Consultation Response from KC,
Lead Local Flood Authority

2025/91531 land off, Leeds Road, Heckmondwike, WF16 9DB

REVISED AND ADDITIONAL INFORMATION RECEIVED, AND REVISED DESCRIPTION:
Demolition of existing semi-detached houses and associated buildings, and construction of 49 dwellings, including associated access and other associated works

Date Responded: 17th April 2026

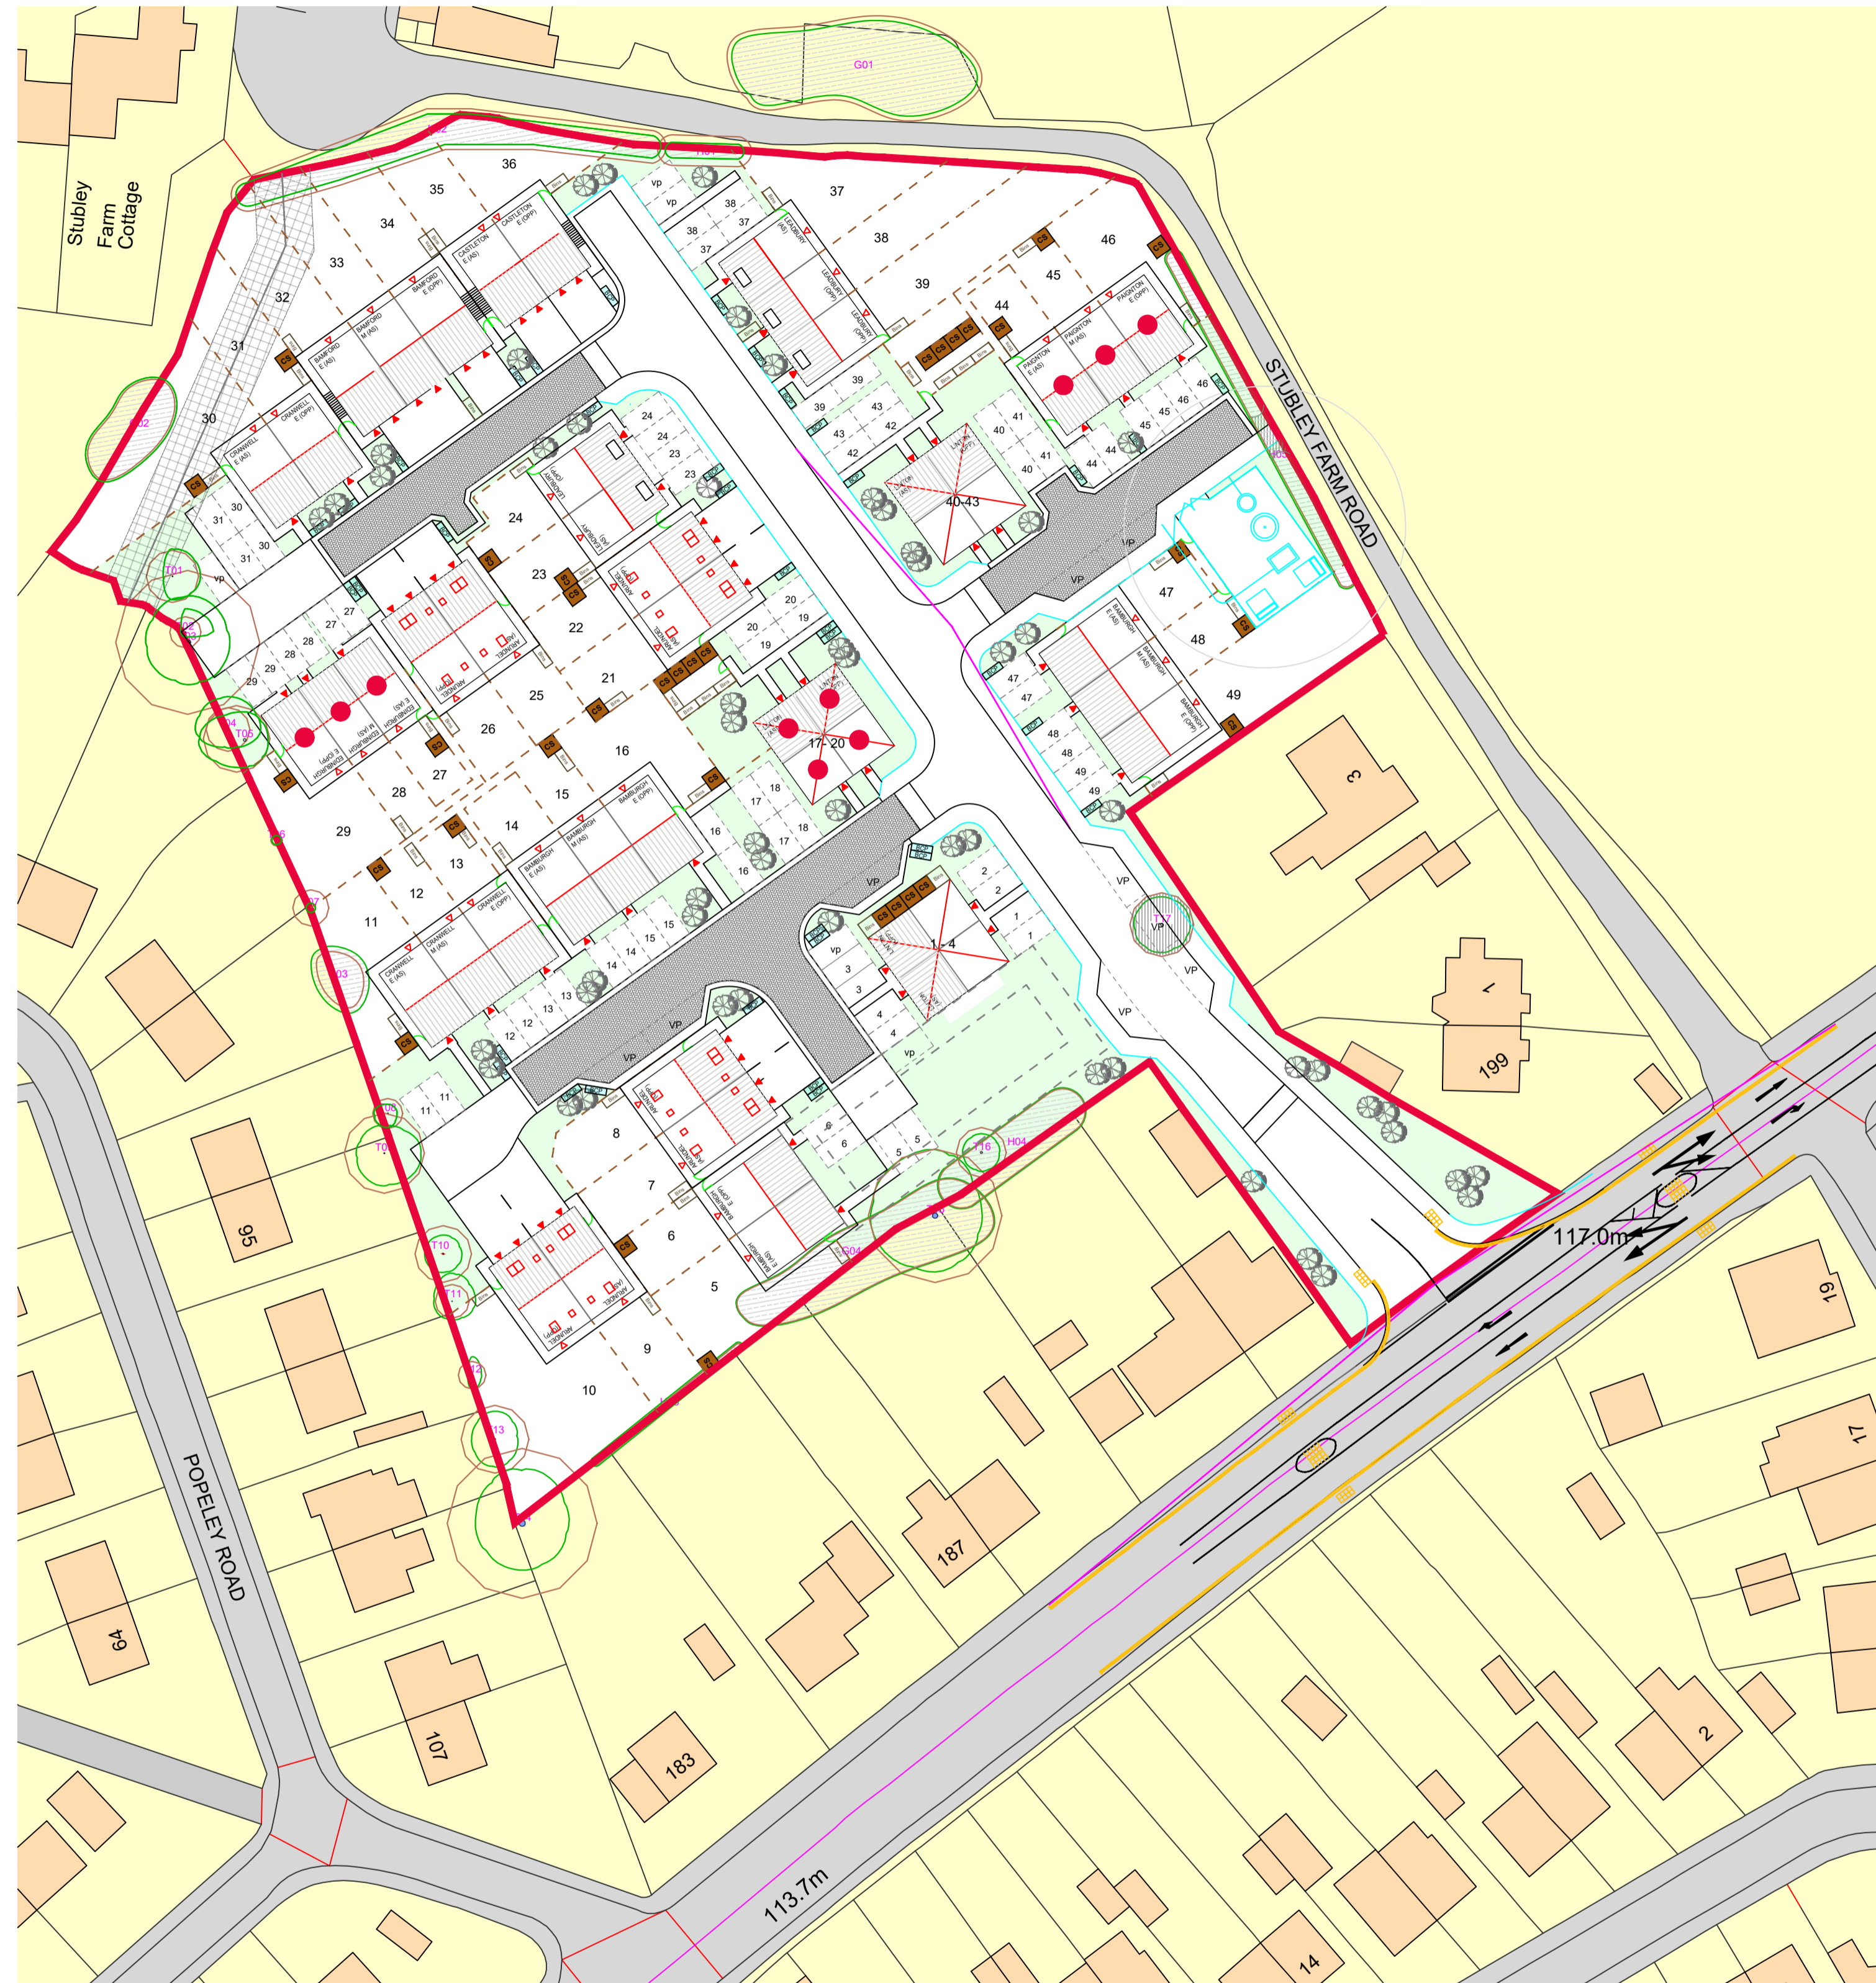
Further to our comments of 2nd September 2025, we OBJECT to this application on the grounds that the layout design has not considered ‘making space for water’ both for blockage scenario flood routing and attenuation requirements.

It would appear that there is an attempt to fit drainage into the layout as opposed to designing the layout around this constraint.

- It is not clear what the boundary treatments are for the perimeter of the site in relation to overland flow (flood routing).
- Flood routing for the site only looks at exceedance events for the tank. In a blockage scenario or a short intense event where water is not entering the system, several plots are at risk by being placed in depressions/low spots and water will enter curtilage and property. There is also little room to alter levels and utilise rear gardens which would be considered under exceptional circumstances. Kirklees LLFA always advise that roads and public open space should be used for overland flood routing avoiding the risk of property flooding in the design.

- The attenuation tank appears to be very close to buildings and is constructed inside curtilage/private driveway and parking areas. This is likely to preclude it from adoption due to the disruption caused if excavations are ever necessary. This will also have a knock-on effect on property foundation design. Roads are unlikely to be adopted if sewers are to remain private.
